Application for Planning Permission for Works or Extension to a Dwelling

Development: Two storey rear chalet extension with three dormer projections.
Location: 135 Nyetimber Lane Aldwick PO21 3HP

1ST FLOOR PLAN

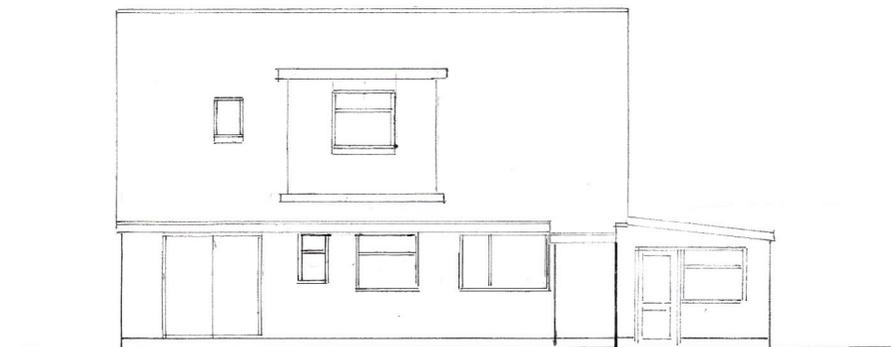
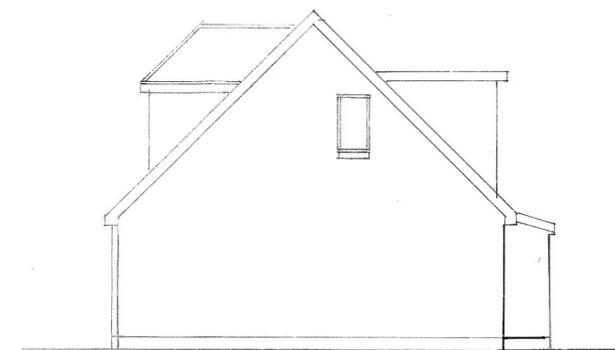
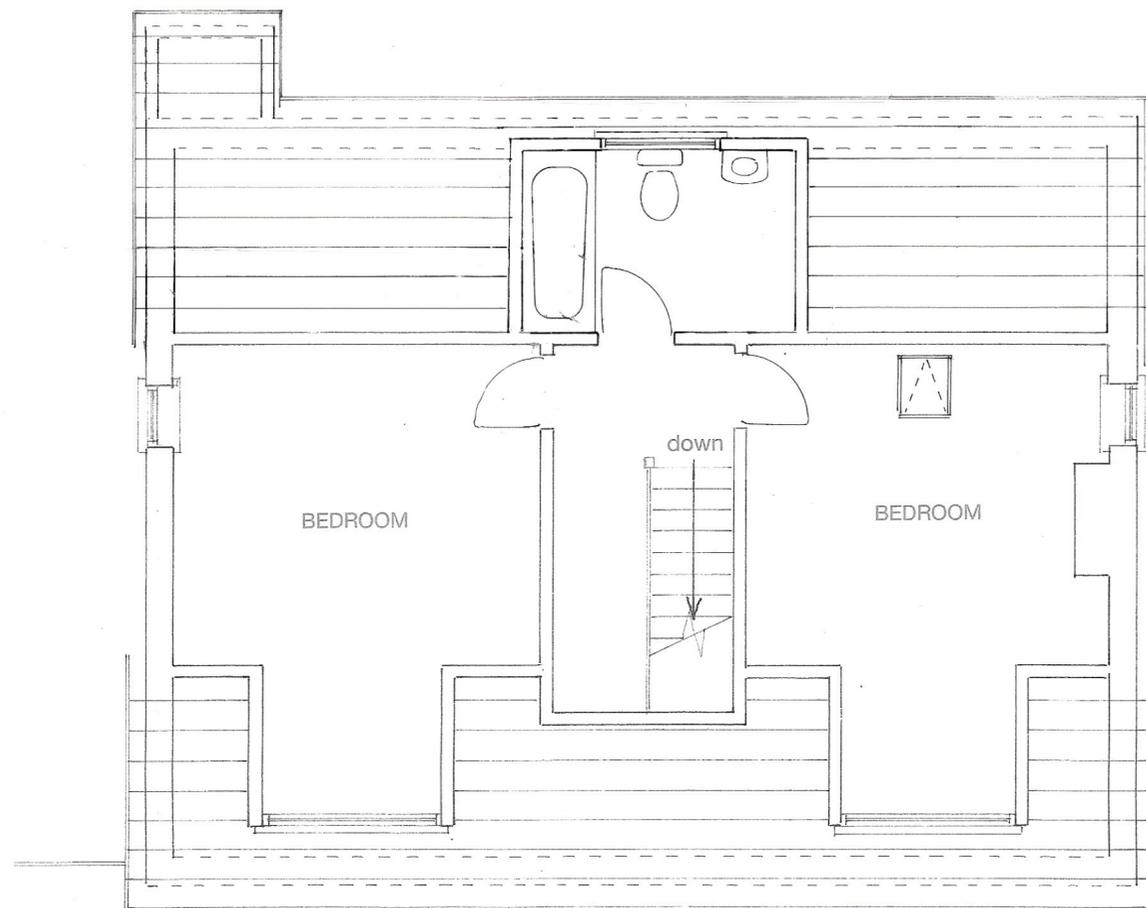
The windows are inconsistent between the proposed first floor plan and the proposed north elevation, please review and amend.
